Town & Country Planning Act 1990 (as amended)
Town and Country Planning (Development Management Procedure) (England) Order 2015
Application for approval of details reserved by condition imposed under planning permission
BN/7/18/PL relating to condition No. 3 (proposed surface water drainage), 4 (Discharge of
watercourse) & 5 (Surface water drainage system)
Land to the north of The Flint Barn Yapton Road, Barnham,

Arun District Council have decided to **REFUSE details reserved by condition for the following reasons:**

Engineers Comments Regarding Conditions 3, 4 and 5

Drawing:
Drainage Strategy

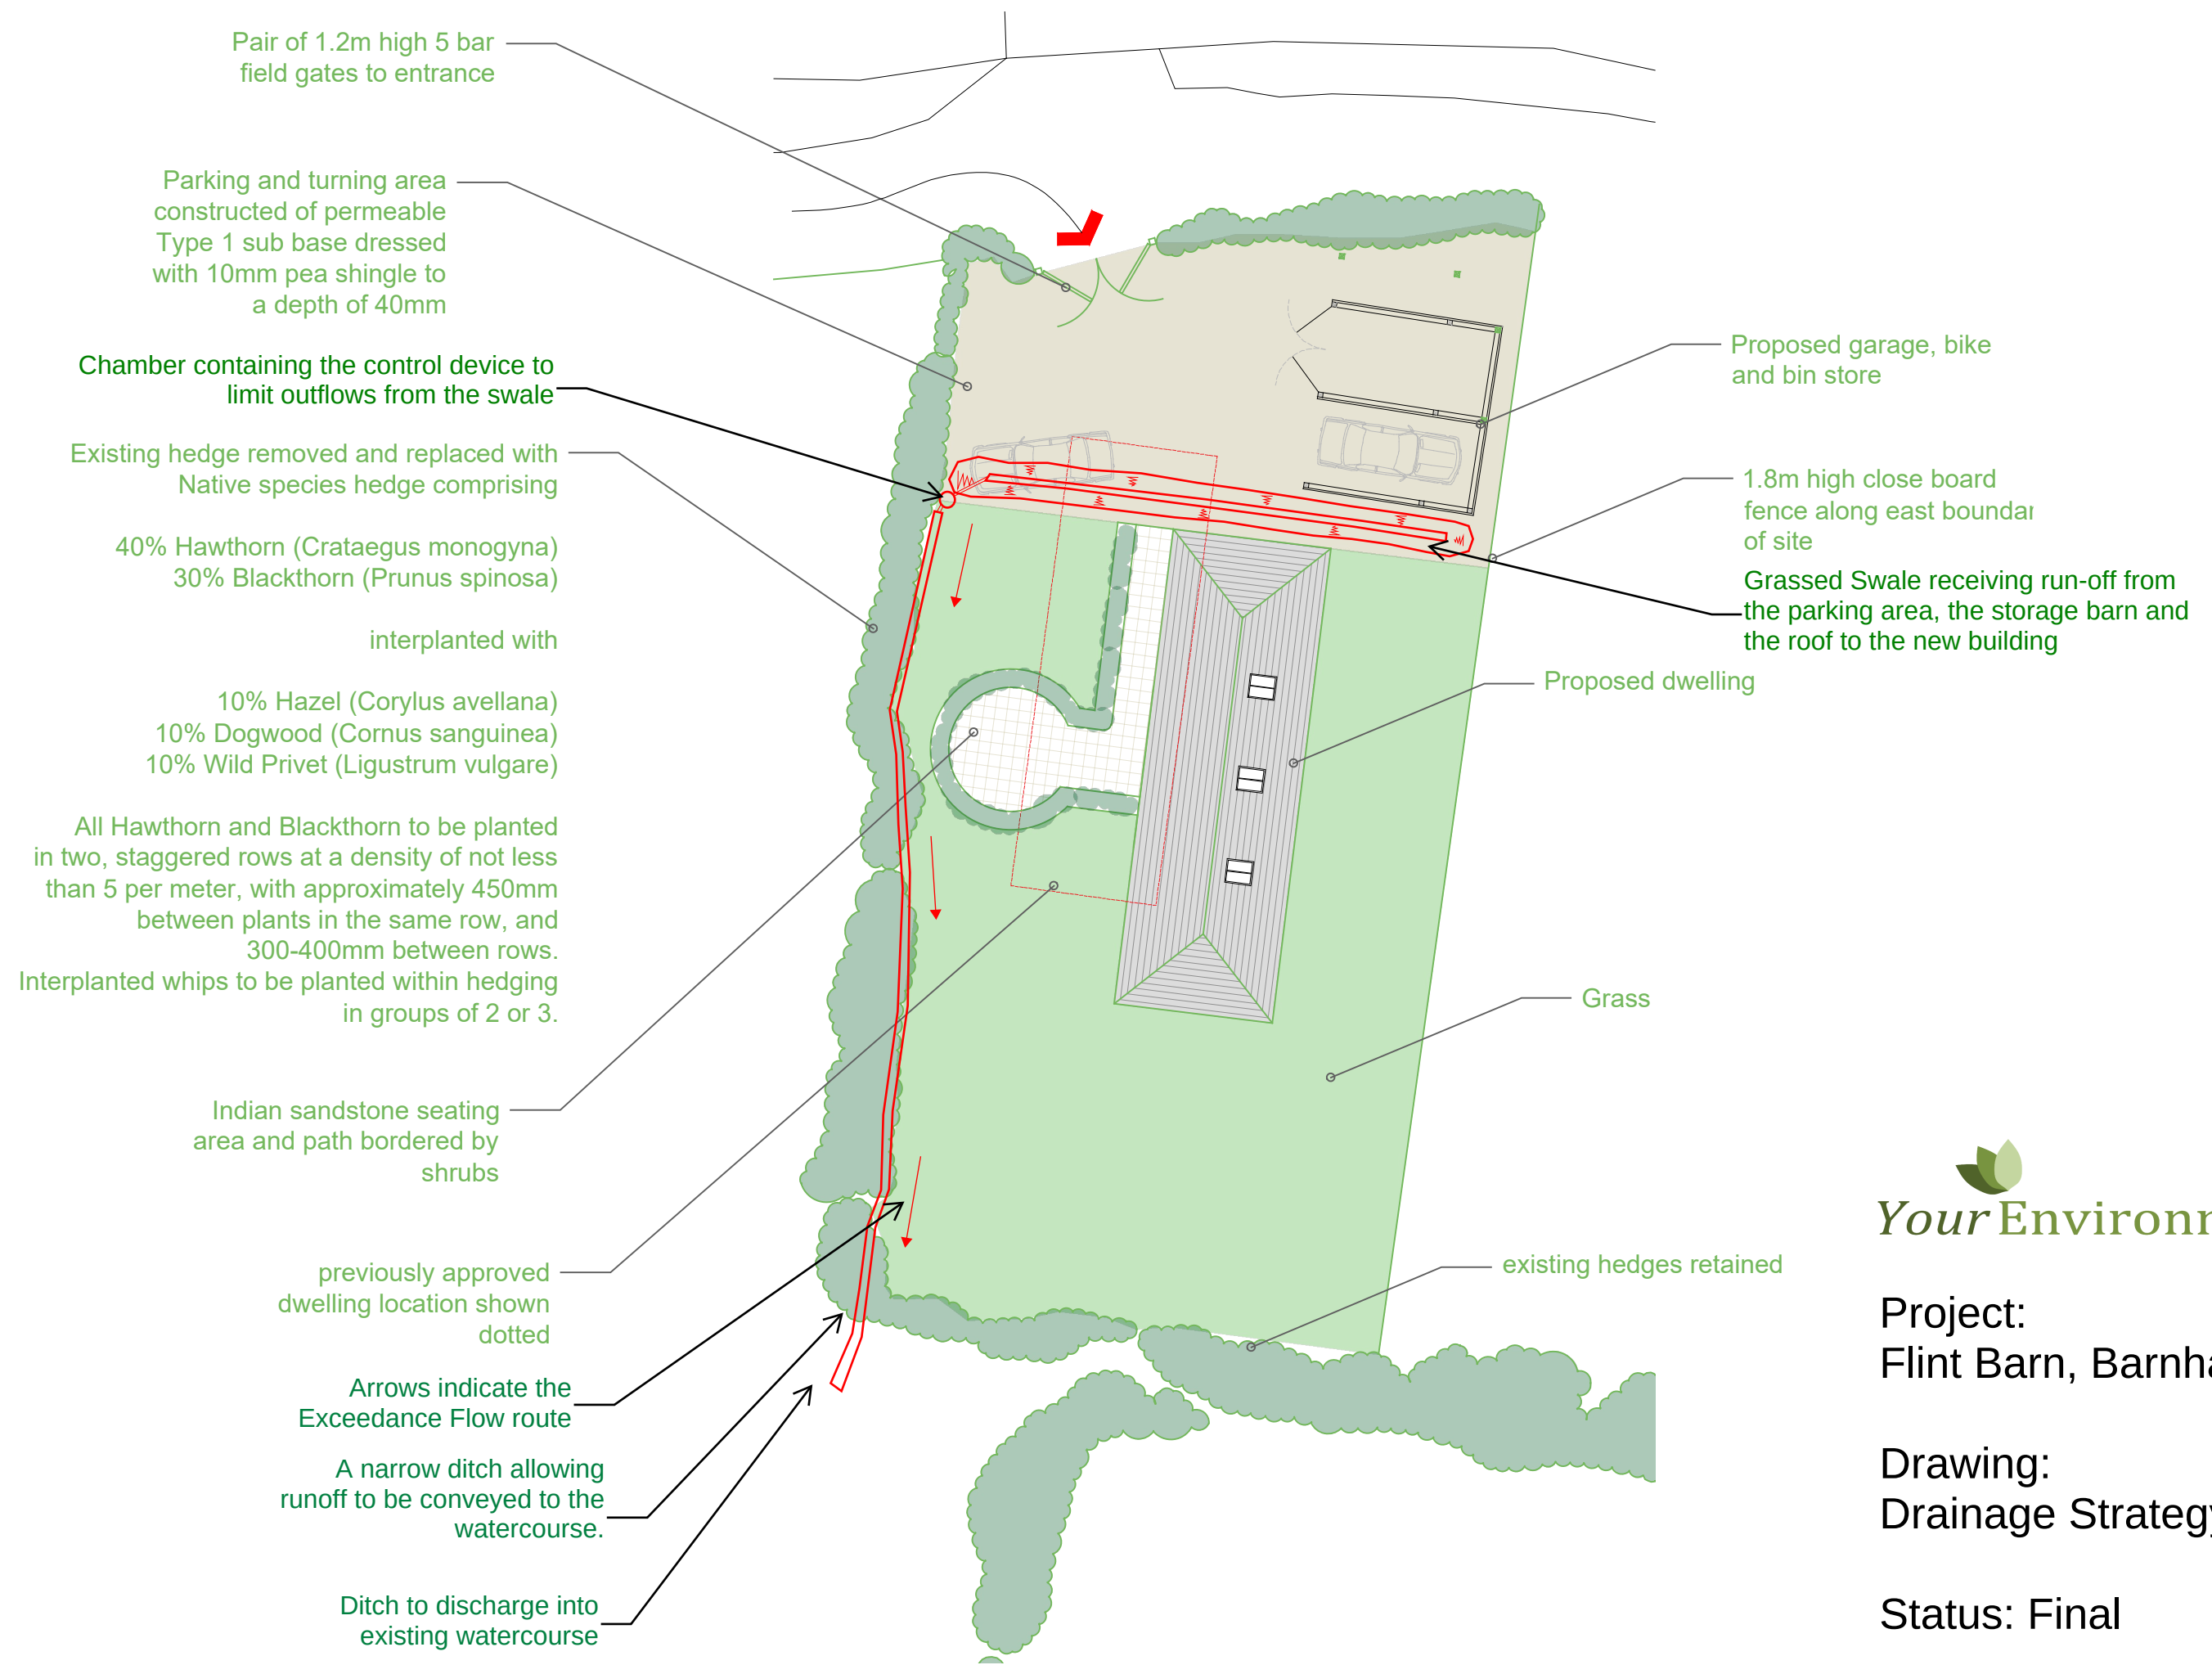
The applicant proposes to form a new swale and connect this into an existing ditch which runs to the south of the site. Winter groundwater monitoring was completed in March, which found ground water levels to be high. We believe groundwater would have peaked before March, therefore may be higher than those levels recorded and we agree with the conclusion that infiltration is unlikely to be viable. However, the applicant may wish to investigate shallow permeable paving solutions. The proposals currently include for the storage of the 1 in 30 year rainfall event on site. Please revise the plans to accommodate the 1 in 100 year plus 40% climate change event on site. Please also clarify the rate of discharge proposed, orifice

diameters have only been provided. In order to discharge flows to an ordinary watercourse the applicant will need to obtain Ordinary Watercourse Land Drainage Consent, (the consent forms will be forwarded separately). I have inspected the watercourse which the applicant proposes on discharging into, it is heavily overgrown. The condition of this watercourse will need to be improved to ensure that flow can be conveyed downstream. The watercourse is culverted and runs under Yapton Road, the condition of this may also need to be reviewed.

Until such a time as consent is obtained and the above points are addressed I do not recommend that these conditions are discharged.
